STATE OF WASHINGTON
DEPARTMENT OF ECOLOGY

September 12, 2016

Re: VA-16-00001

Thank you for the opportunity to comment on the notice of application for the zoning setback variance proposed by Aaron Mostofi. We have reviewed the application and have the following comment.

VA-16-00001

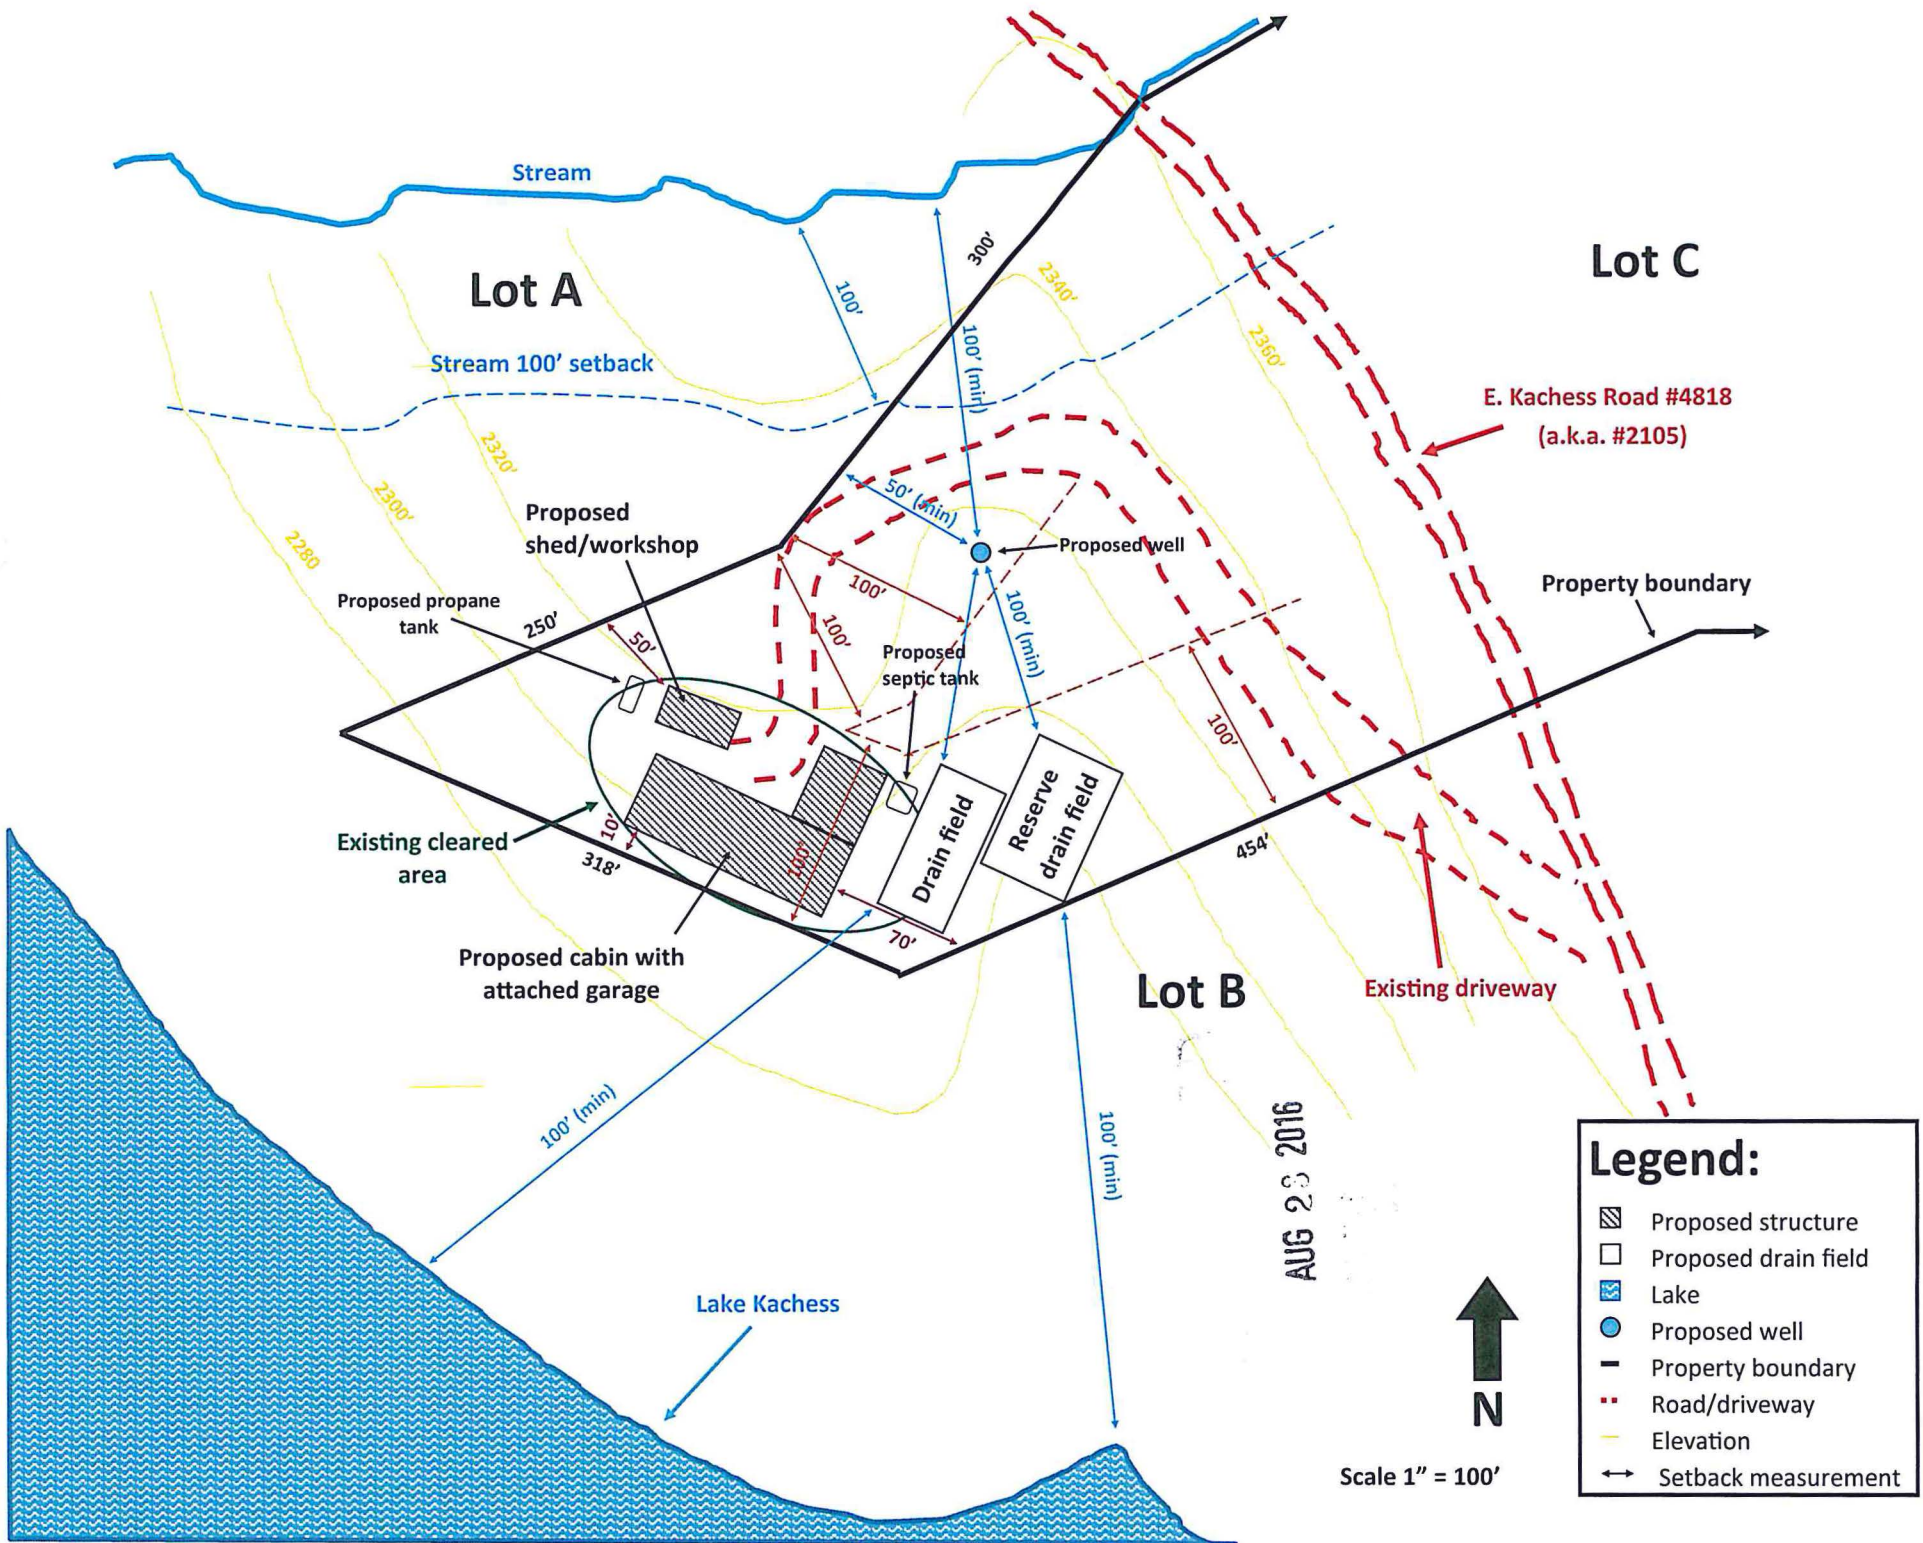
Approval of this development may require a shoreline variance permit if any development (including any appurtenances such as garages or sheds) occurs within the 100-foot setback from the OHWM of Lake Kachess or within required buffers from wetland areas. The project will require a shoreline permit exemption action if the development will occur within 200 feet of the OHWM. No mention is made regarding what the shoreline designation of this shoreline area is. The submitted map shows only that the setbacks will be "a minimum of 100 feet back" from the OHWM. A map that is adequate for shoreline review and filing purposes should show actual distances. Measurements taken via a google earth pro application show the cleared area being a little bit more than 200 feet from the visible lake level. The managed Lake level will be lower in elevation and below the OHWM due to wind and wave action. It takes a foot or more of water underneath large woody debris to move it. Therefore, the OHWM is typically higher in elevation than the debris line.

The aerial photo provided by the County for review appears to show low wet areas underneath the canopy of the trees adjacent to the Lake. These low wet areas are located toward the proposed development area. Therefore, the OHWM may extend further landward than the existing debris line toward the proposed house. In addition, the closest portion (perpendicular distance) of the proposed development to the Lake OHWM should be measured in order to determine whether a variance is needed.
